**DELEGATED DECISION FOR APPLICATION FOR CERTIFICATE OF LAWFUL  
DEVELOPMENT**

Reference no.: 2024/CL/90630/W

Site: West Lodge, New Hey Road, Fixby, Huddersfield, HD2  
2EJ

Description: Certificate of lawfulness for proposed erection of  
detached garage and store

West Lodge New Hey Road. Fixby. HD2 2EJ
Proposed Location for Garage
Scale 1:100 @ A4

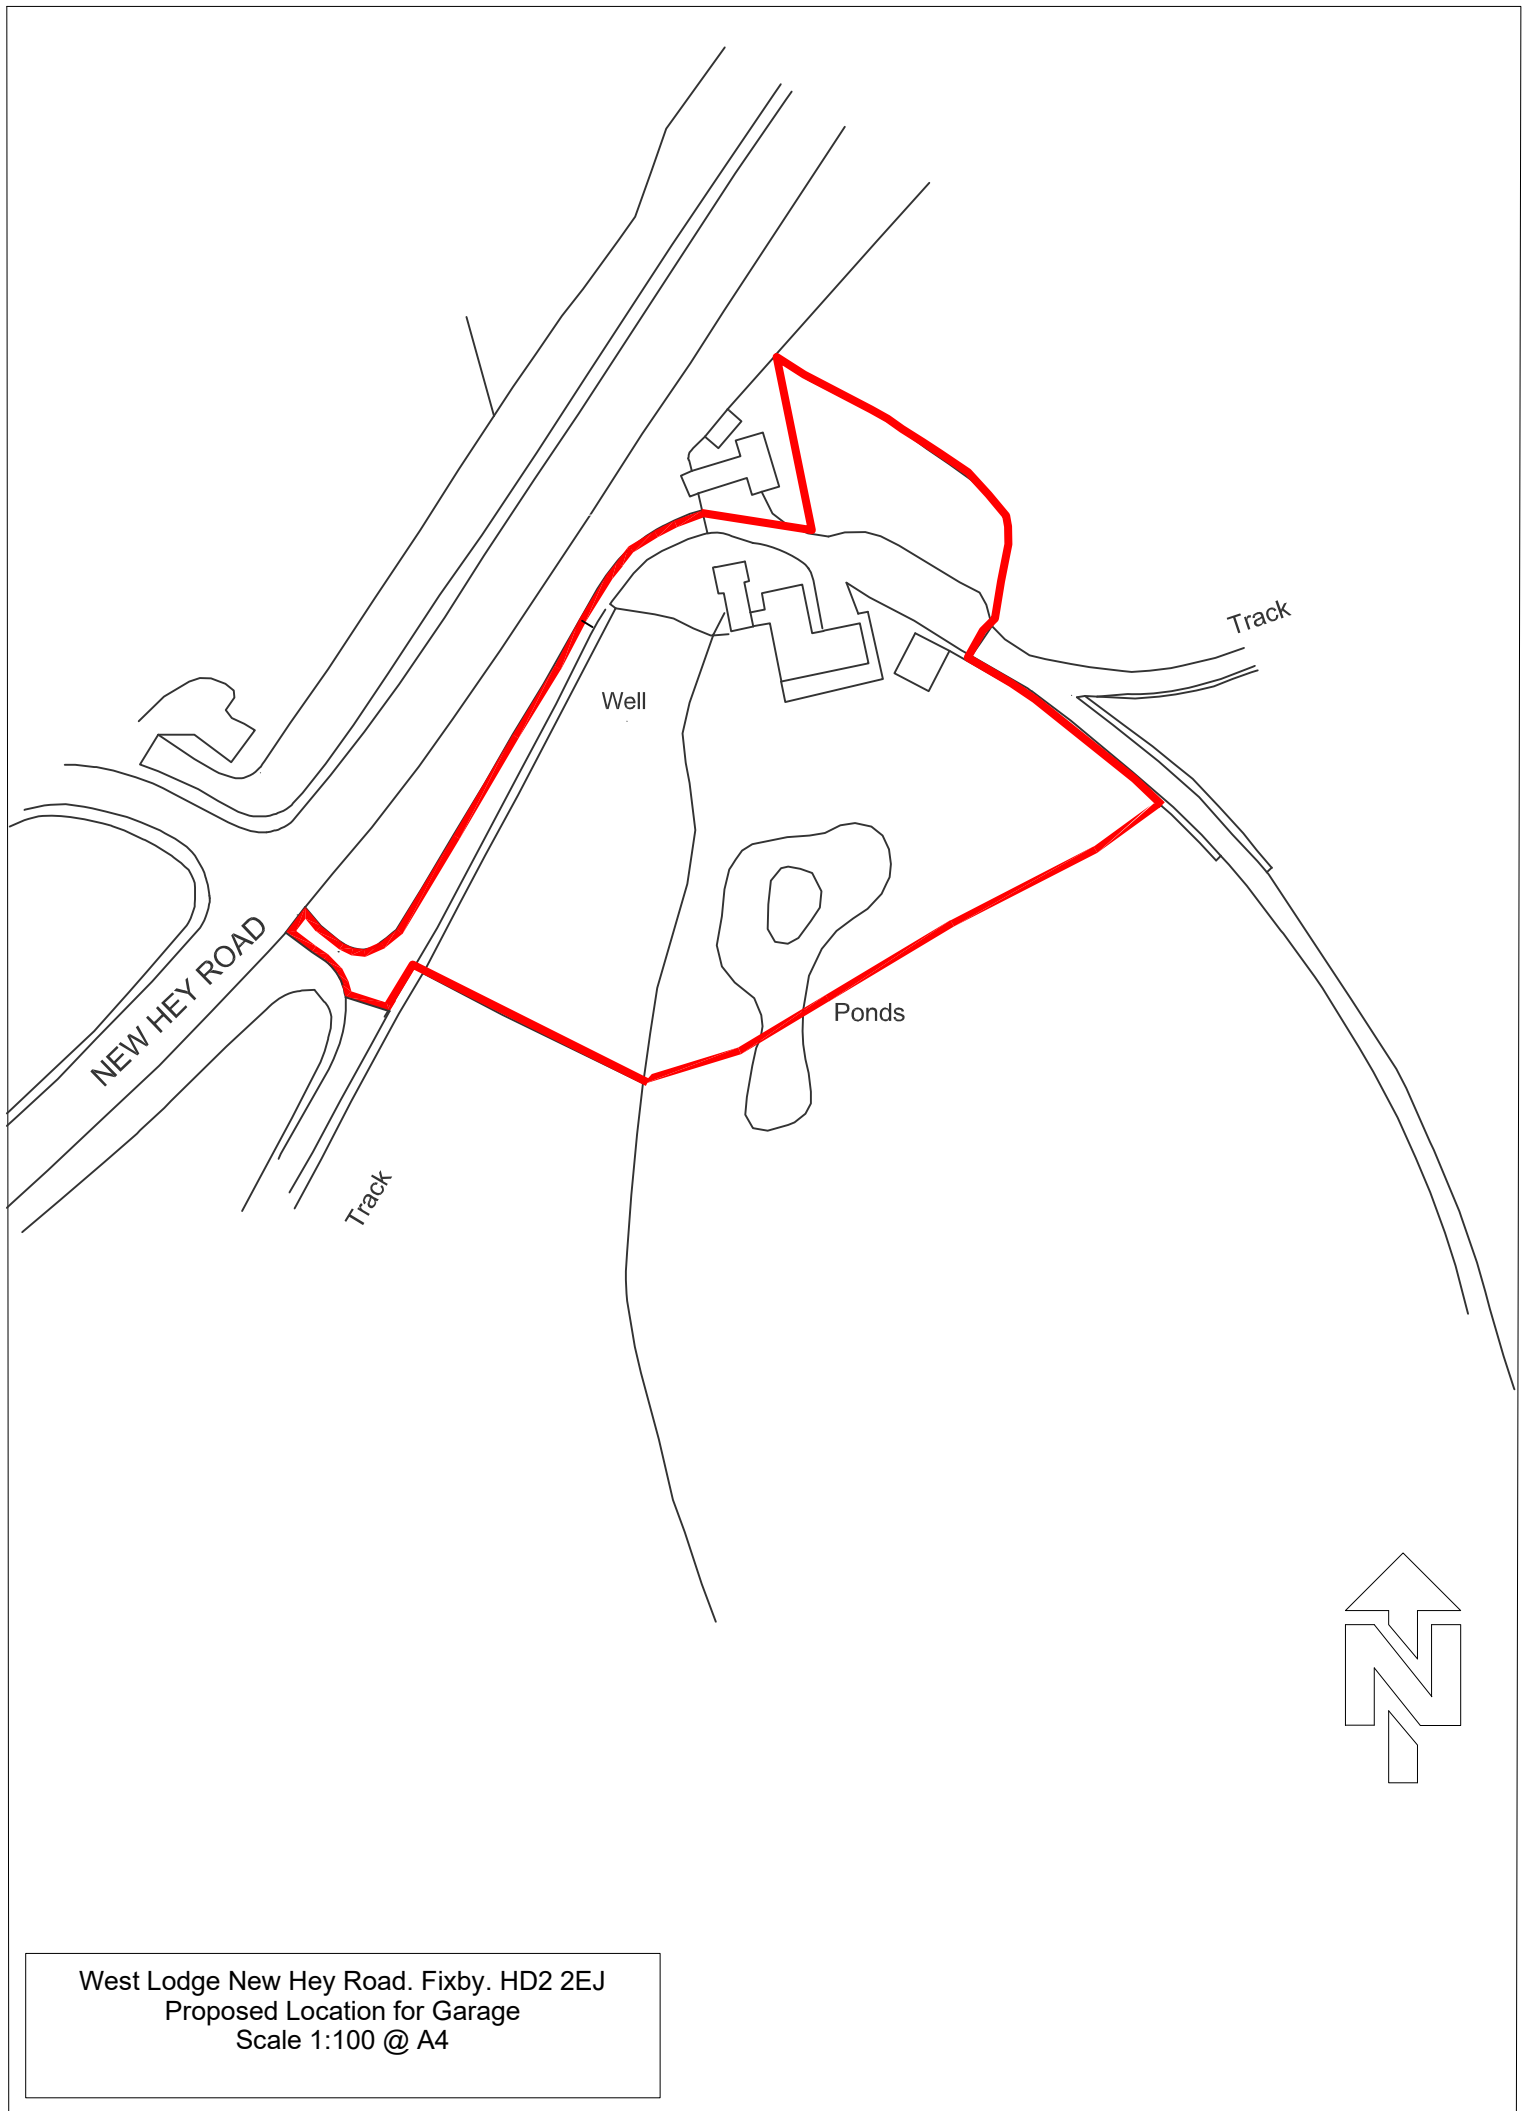
With respect to the applicant's view, it is considered that the outbuilding would be situated forward of the principal elevation. Taking into account the definition of 'principal elevation' set out in the Governments technical guidance note, it is considered that the main entrance to the house is situated on the original principal elevation located to the north facing obliquely towards the highway serving the dwellinghouse. The southern elevation of the dwelling fronts the garden, which is accessed via a set of patio style doors. The patio doors lead onto a raised terrace which houses residential paraphernalia such as a hot tub and patio chairs/tables which are often not typically associated with the front of a property.

Additionally, due to its location to the north of the site, the land is separated by a track between the land and the dwellinghouse which is in different title to the dwellinghouse and apparently in separate ownership given the track is in the same title as the radio antenna located to the north east. Consequently due to the physical separation of the parcel of land where the proposed garage and store is to be located, the proposed building is not considered to be within the residential curtilage of the dwellinghouse by virtue of physical separation of land in different ownership and therefore not forming one enclosure that could be considered curtilage.

*The building would be located forward of the principal elevation of the original dwellinghouse, being placed to the north of the dwelling.*

*The height of the eaves of the building is proposed to be 3 metres, exceeding 2.5 metres.*

The proposed detached outbuilding does not benefit from a general planning permission under the provision of Article 3(1) and Schedule 2, Part 1, Class E of the Town and Country Planning (General Permitted Development) (England) Order 2015 (as amended), as the proposed outbuilding would not be within the curtilage of the dwellinghouse contrary to the provisions of Part 1 and would in any event be forward of a wall forming the principal elevation of the original dwellinghouse and the eaves height would exceed 2.5 metres contrary to Class E sub-paragraphs (c) and (f)..
